FULL

Reference: H16-0795-16 **Date of Decision:** 31st October 2016
Applicant: Miss Kristina Pasakinskaite
21 Lilburn Drive
Spalding
Lincolnshire
PE11 3NY

Location: 21 Lilburn Drive Spalding
Description: Proposed fence

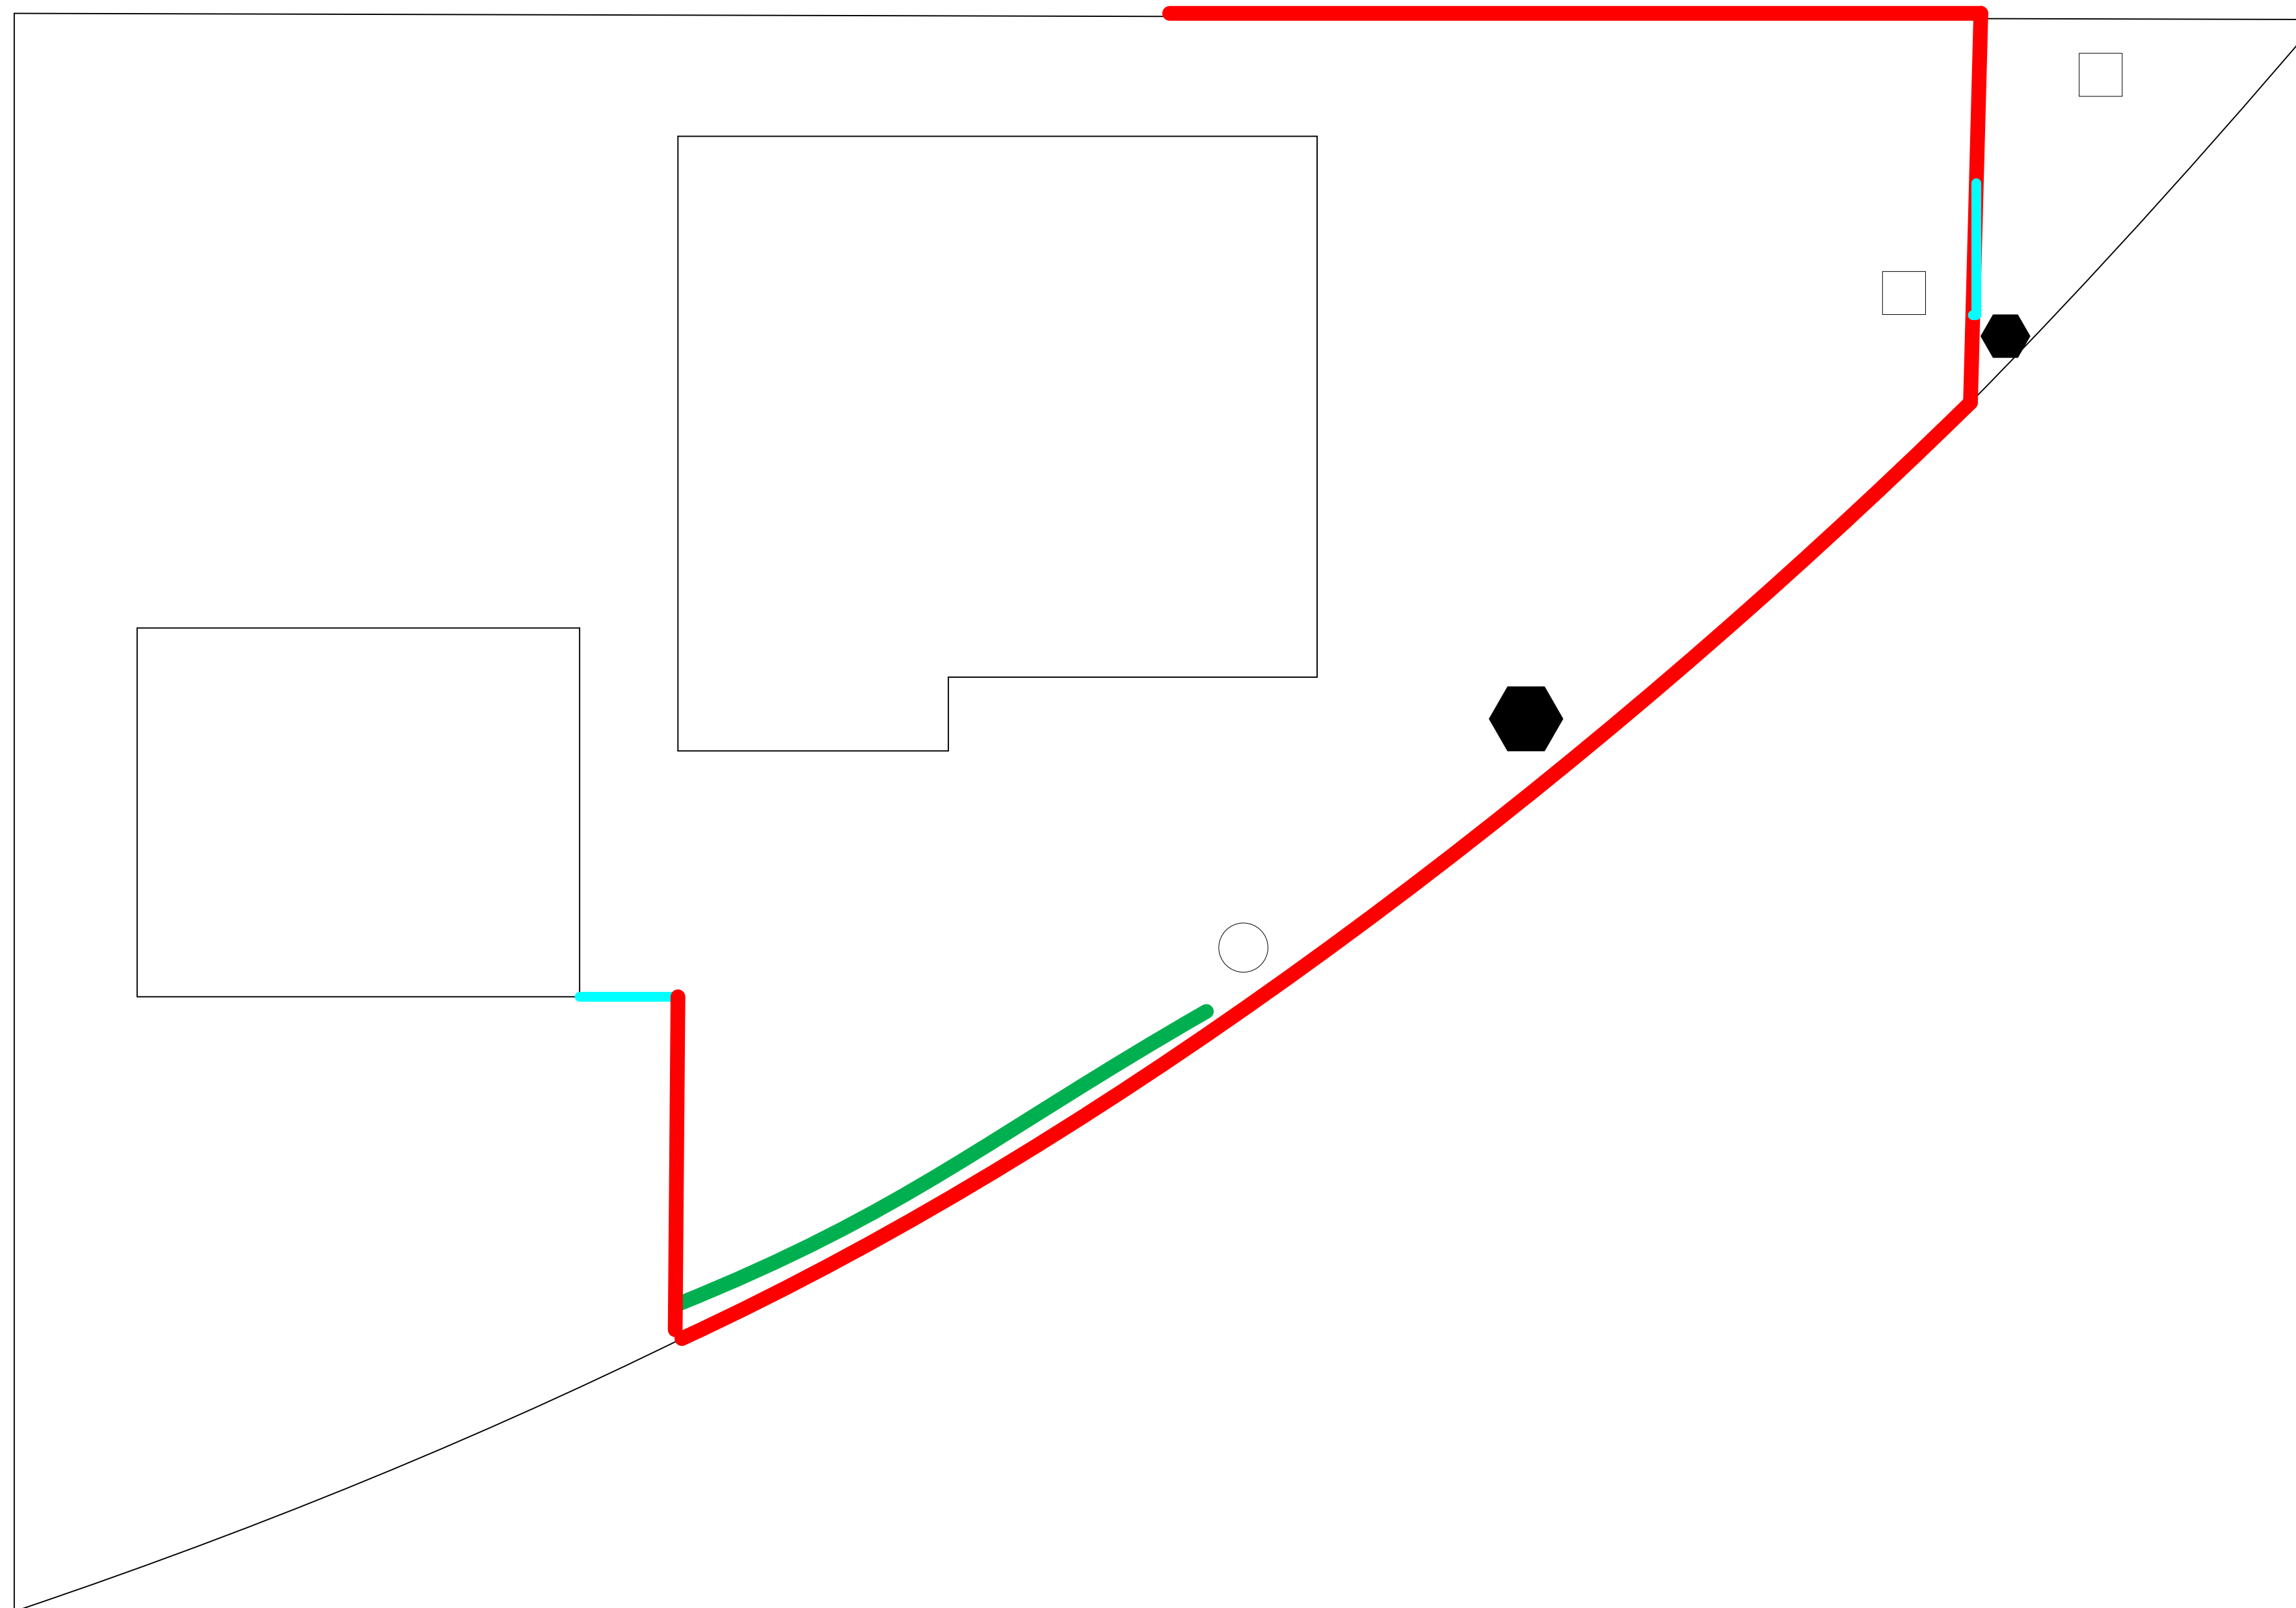
- 1 The erection of a fence to a height of 1.6 metres would be an overly dominant feature within the local streetscene due to the height and length of fence proposed, which would detract from the overall visual quality of the local area. The proposal would therefore conflict with Local Plan Policy SG14 which only allows new development that makes a positive contribution to the architectural and visual quality of its surroundings, and which does not permit development that would have an adverse effect on the character and appearance of the area. This policy is in accordance with national guidance contained in Section 7 of the National Planning Policy Framework, 2012.
